# COUNTY COUNCIL'S RESPONSE TO CONSULTATION ON THE FOLLOWING DEVELOPMENT PROPOSAL

**Application No:** 18/02169/F-2

**Proposal:** Temporary change of use of the eastern part of southern taxi way for use in connection with established and lawful car processing operations

**Location:** Heyford Park, Camp Road, Upper Heyford

Heyford Park - Site Perimeter Security Arrangements

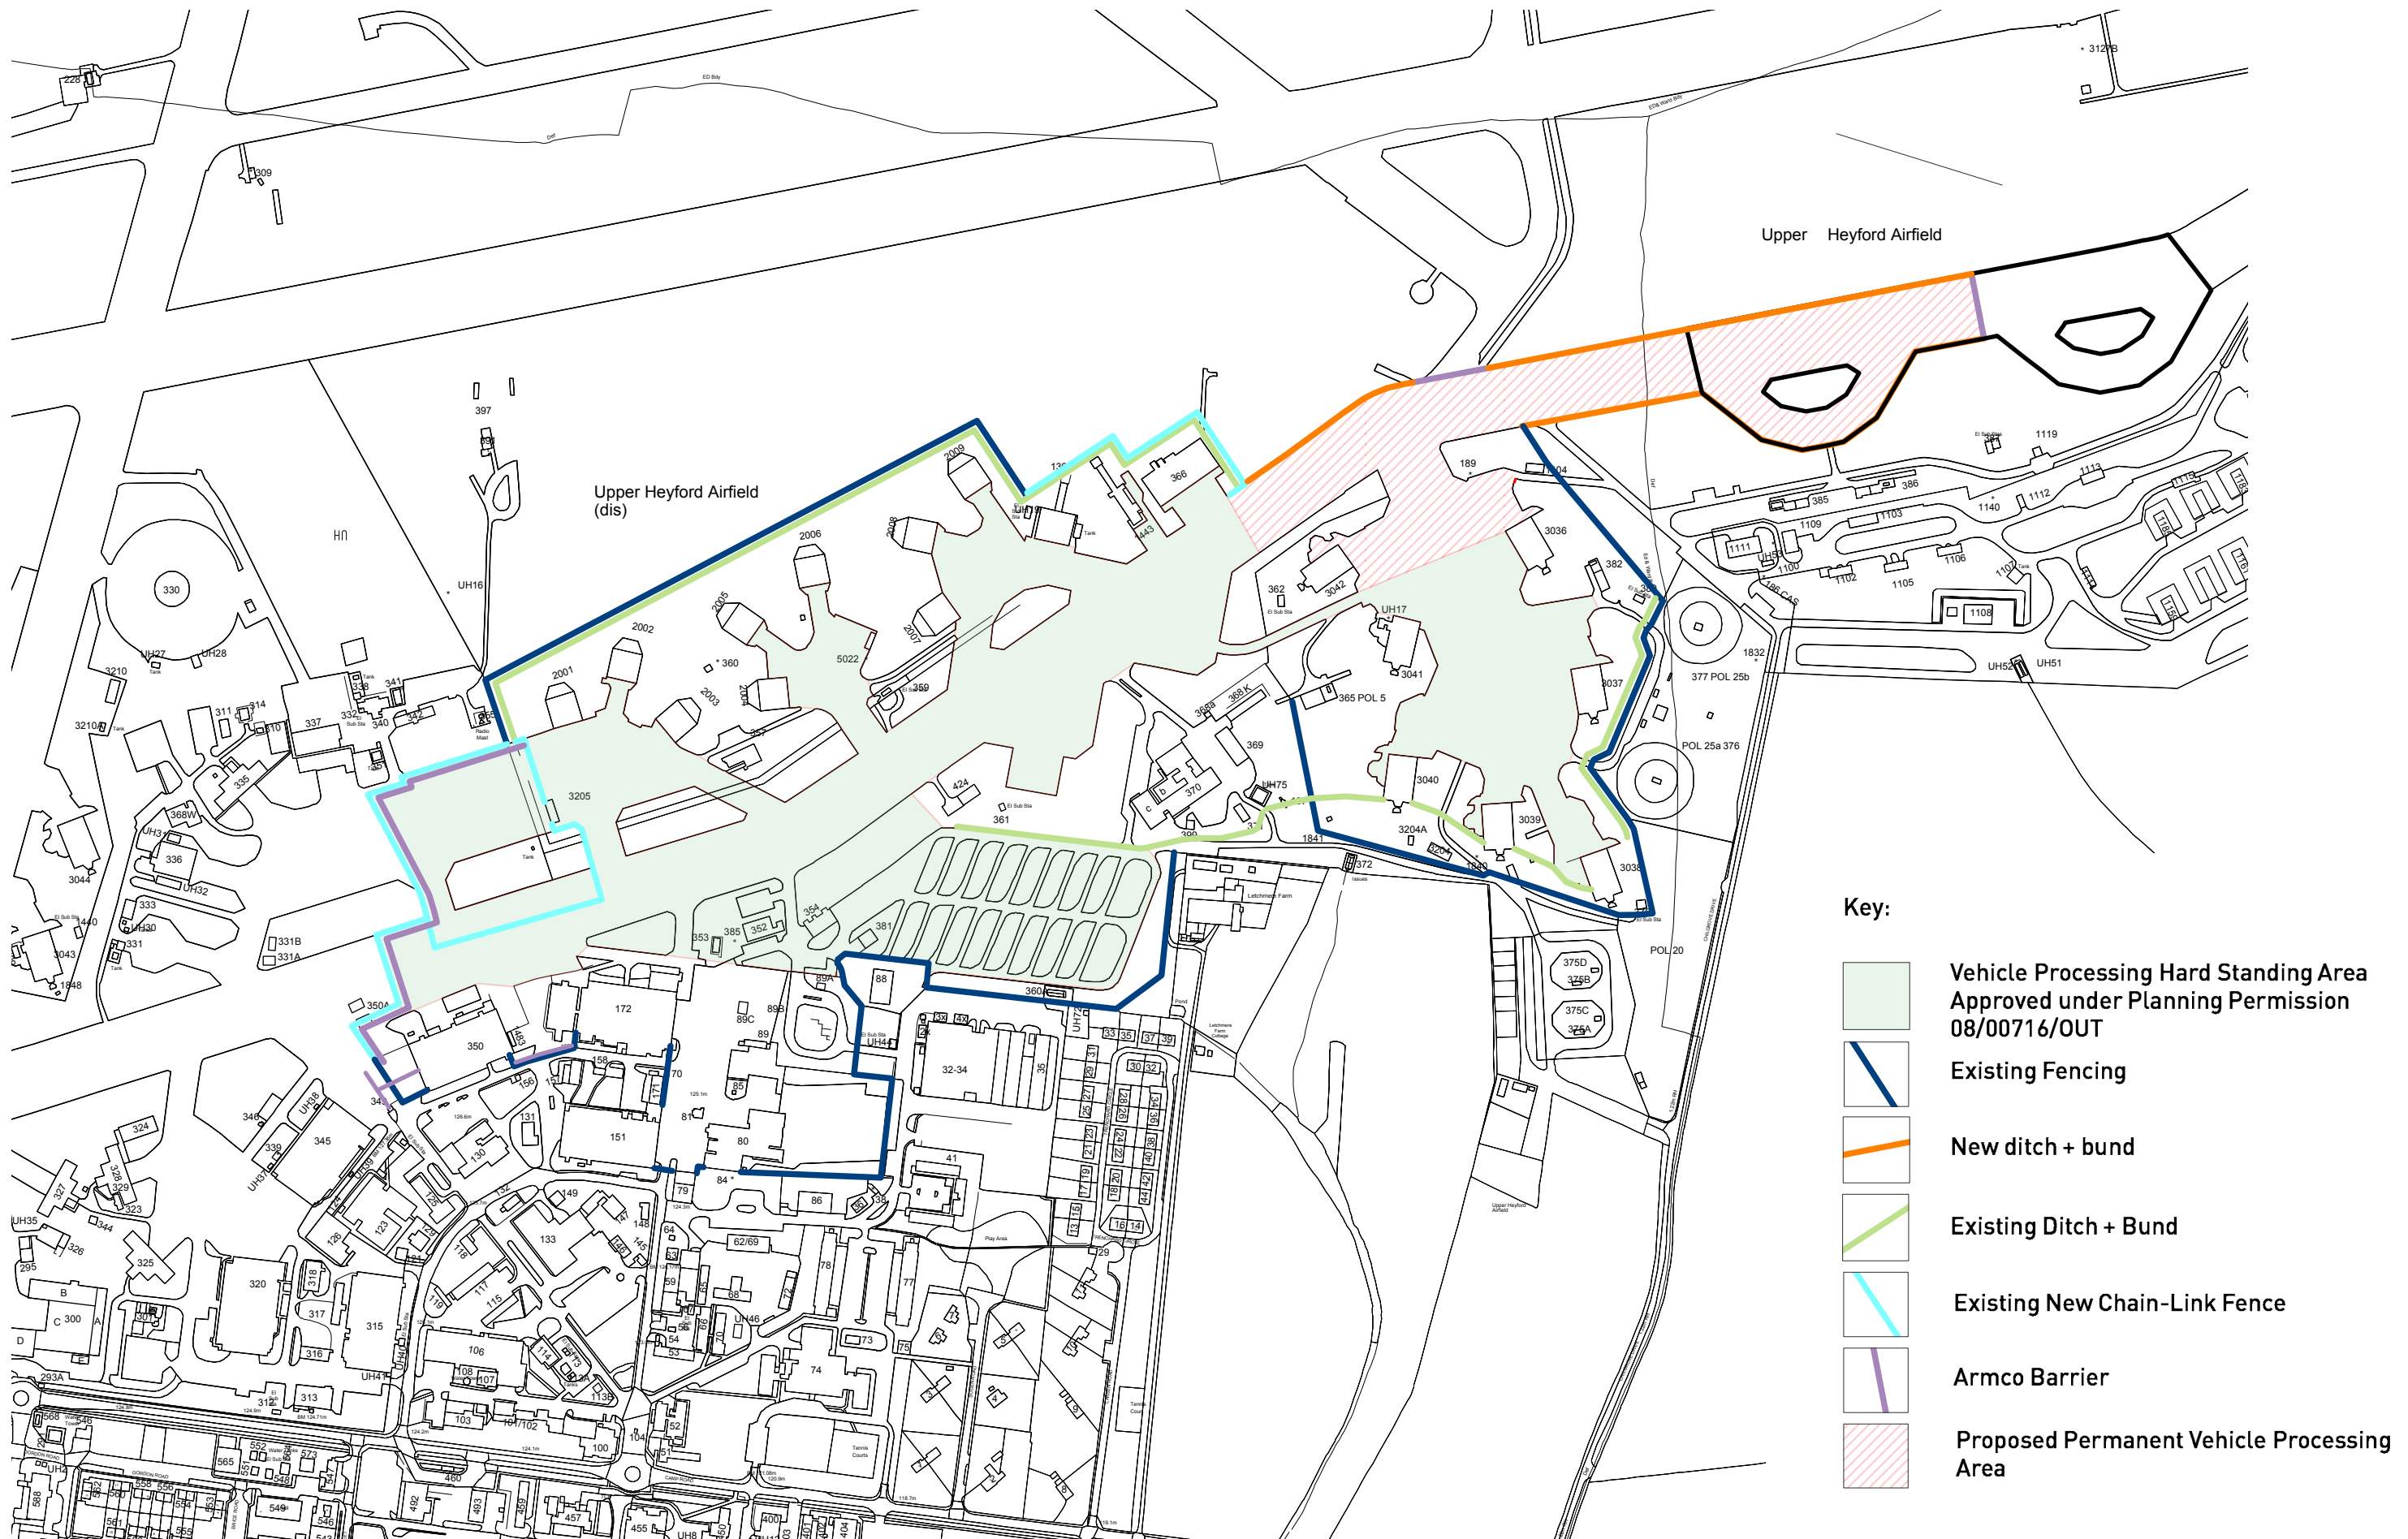
- The construction and location of the security fencing must not impede the construction of the Bomb Stores bus loop.
- The proposals could affect the alignment of the Aves Ditch public right of way.

However, the early construction of the bus loop is of fundamental importance in delivering the agreed bus strategy to separate the Oxford and Bicester bus services and provide two turning loops. Therefore the construction and exact location of the security fencing must not impede the construction of the Bomb Stores bus loop. This can be achieved is discharge of a condition of planning permission.

Prior to the commencement of the development a plan showing the location and construction of the security fencing such that it does not interfere with the construction of the Bomb Stores bus loop shall be submitted to the Local Planning Authority for approval. Thereafter the security fencing shall be located and constructed according to the details shown on that plan.
